**re: Grading Plan Review**  
Proposed Residential Development  
2506 Innes Road – Ottawa, Ontario  
**to:** Concorde Properties – **Jordan Tannis** – [jt@concorde-properties.ca](mailto:jt@concorde-properties.ca)  
**date:** May 1, 2024  
**file:** PG6818-MEMO.02

## **Grading Plan Review**

- Grading Plan – 2506 Innes Road – Job No. 23087 – Drawing No. C4 – Revision 3 dated May 1, 2024.

Drawn
D.B.G.
H. Scale
1:200
V. Scale
Date
Dec 20-23
Job No.
23087

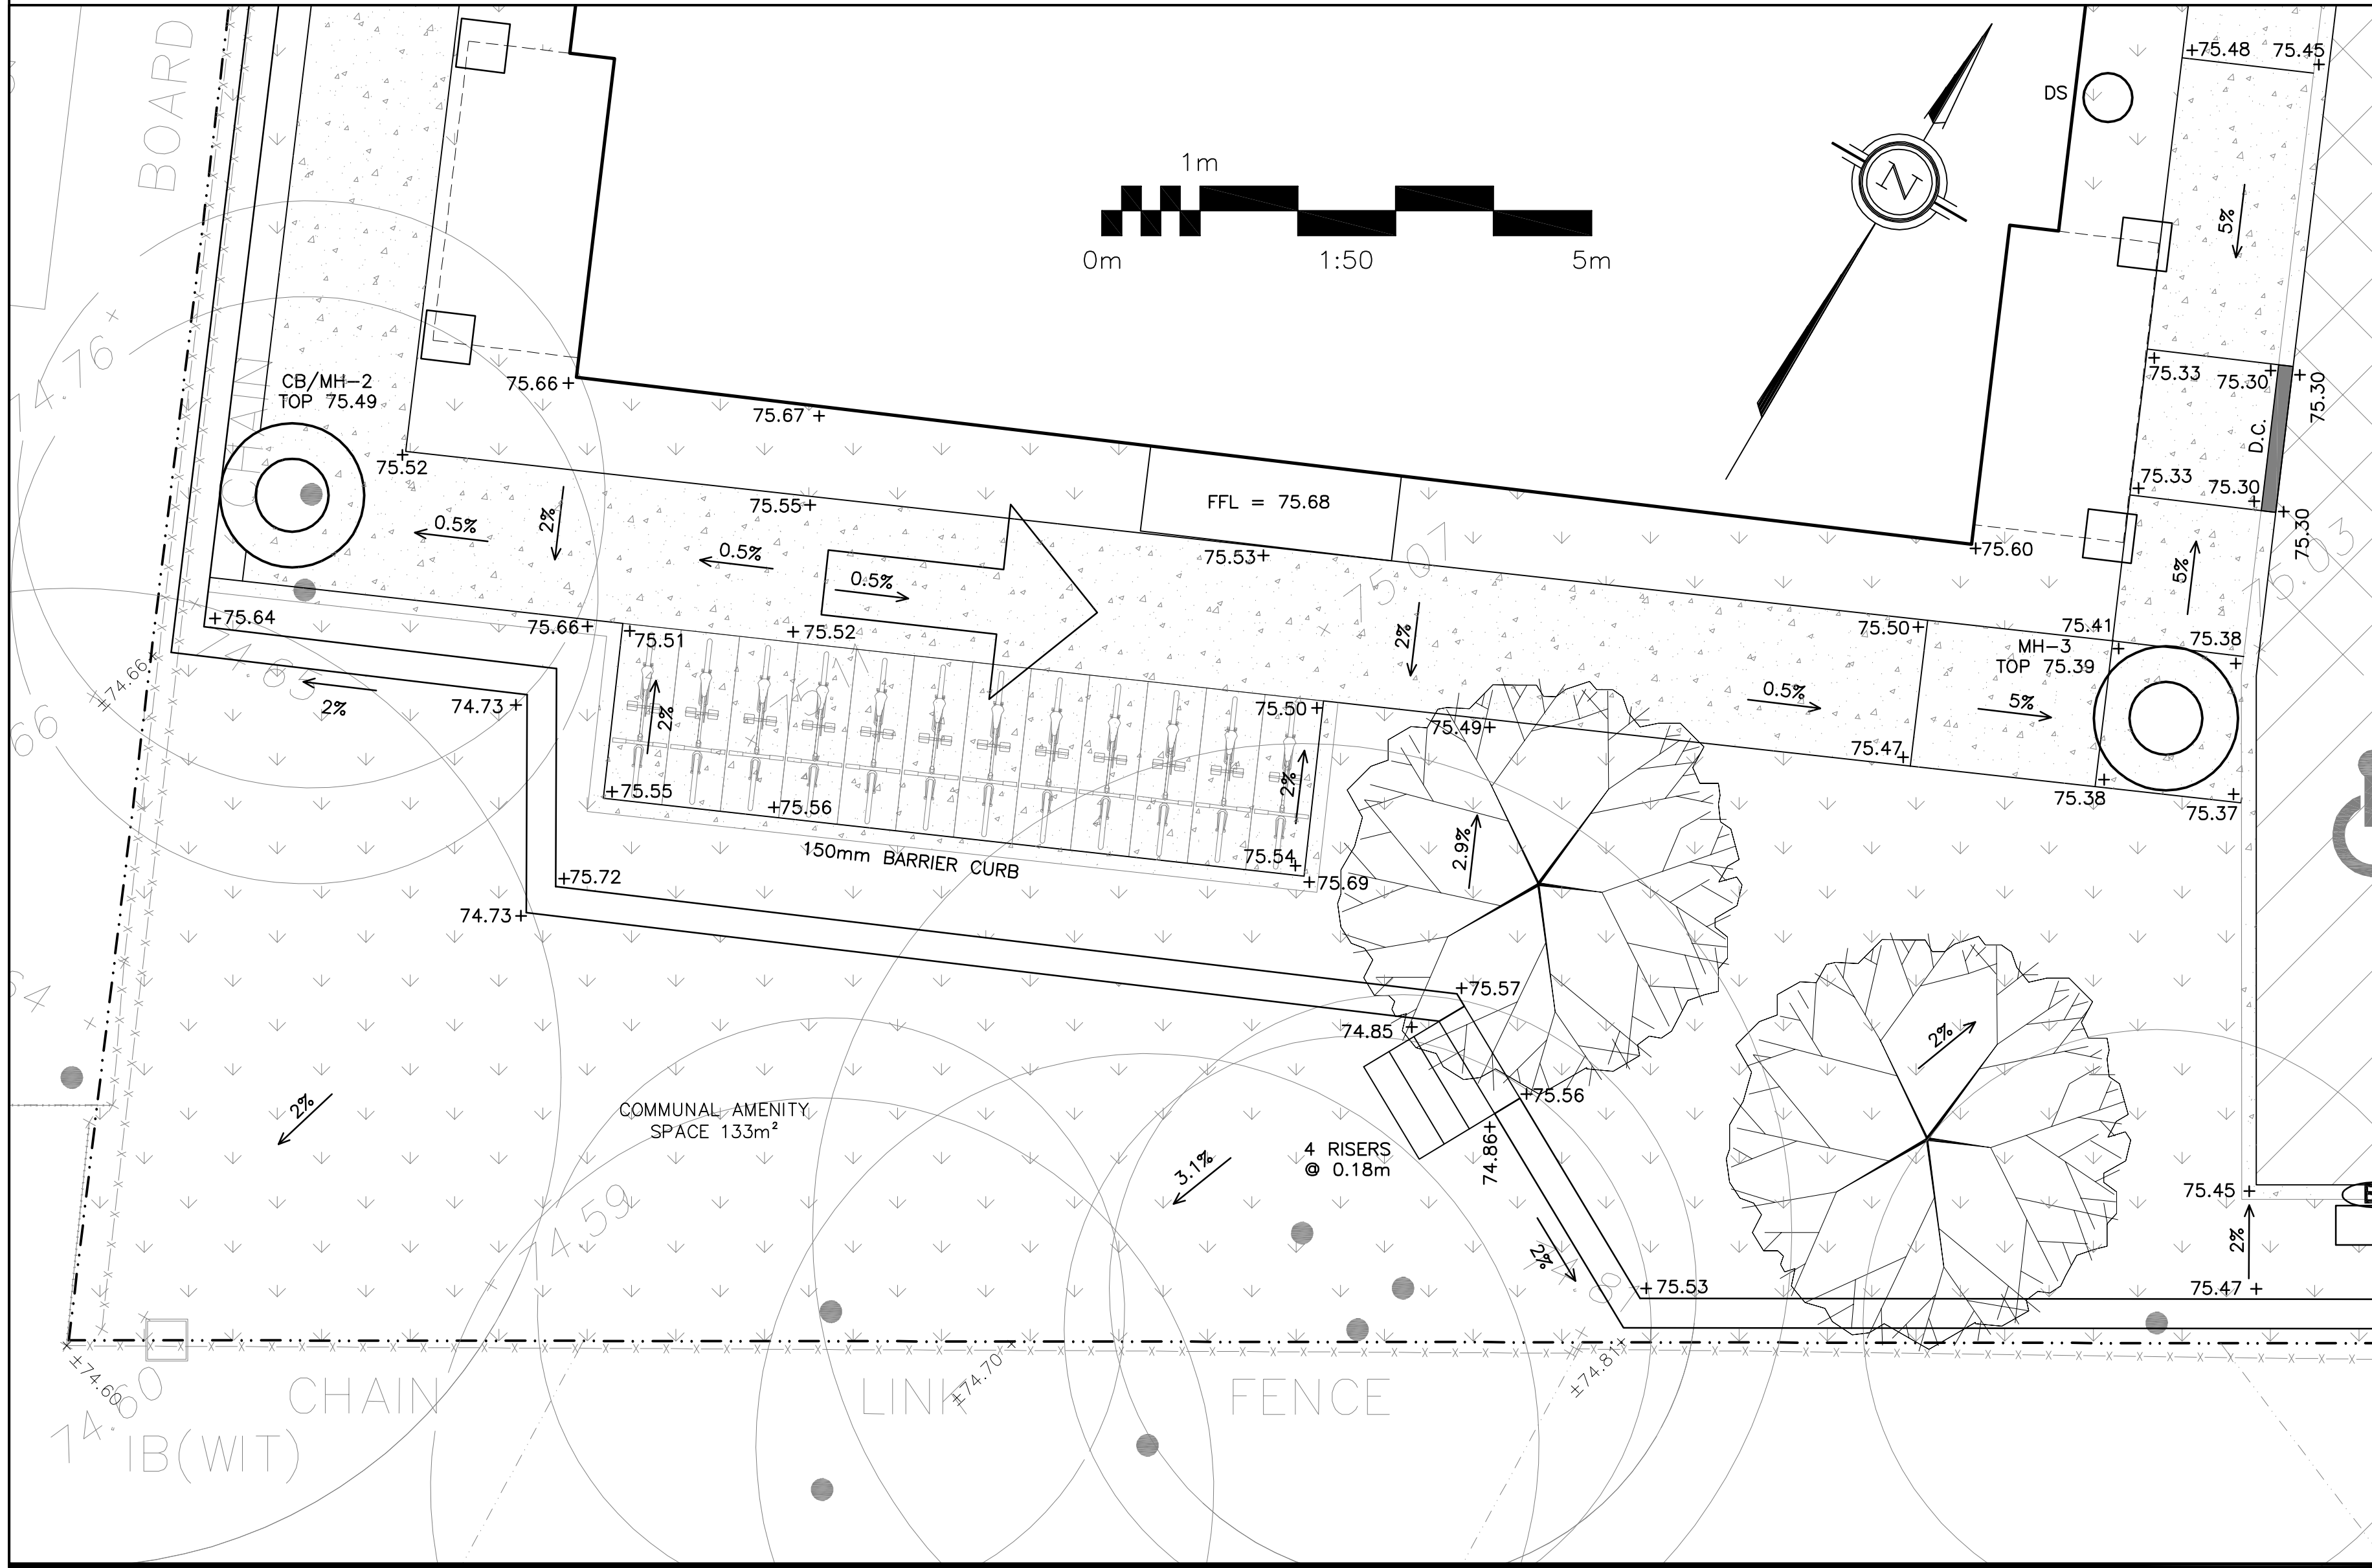
Due to the presence of a silty clay deposit underlying the subject site, a permissible grade raise restriction of 1.5 m was recommended for grading at the subject site. Based on our review of the grading plan, no grade raise exceedances were noted, as such, the proposed grading is considered to be acceptable from a geotechnical perspective.
